Tel: 01903 737756
Email: planning@arun.gov.uk
www.arun.gov.uk/planning
Please ask for: Ms Iqraa Malik
Email: iqraa.malik@terraquest.co.uk
Telephone: 0121 234 1390
Our Ref: BE/118/25/HH
Your Ref:
Date: 2nd October 2025

Application for Planning Permission for Works or Extension to a Dwelling

Development: Single storey side extension.
Location: 4 Violet Close Bersted PO21 5FS

Proposed Ground Floor

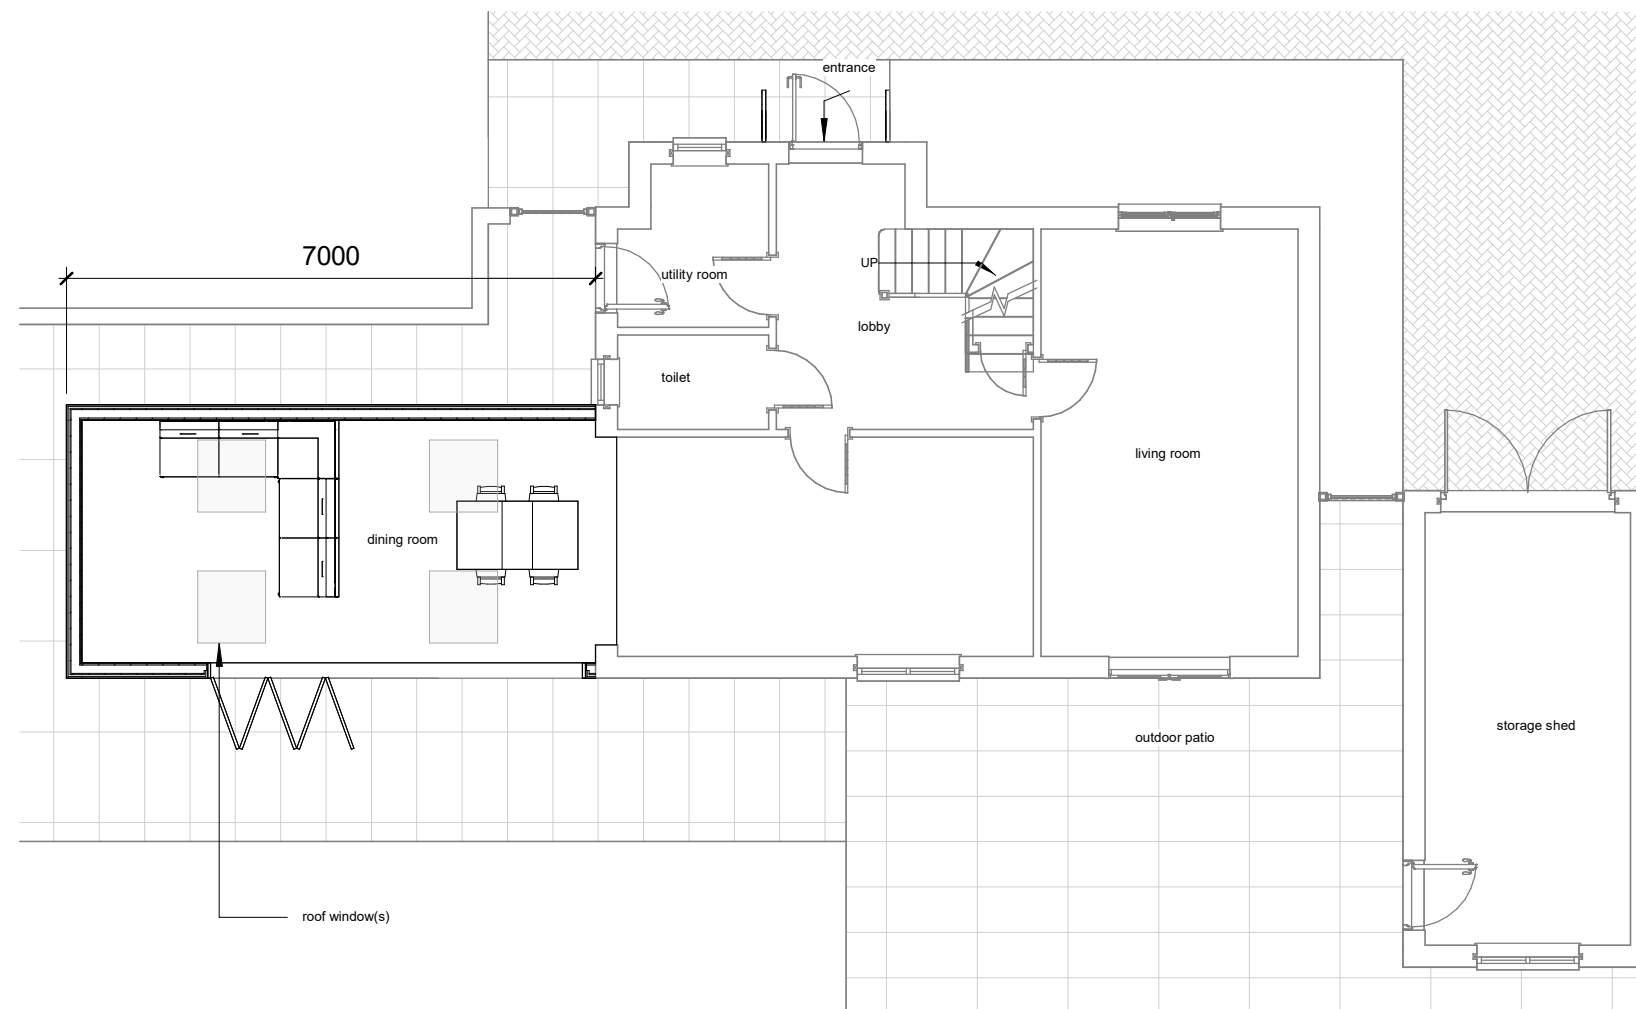
Rooflights

Please show the proposed rooflights on the floor plans.
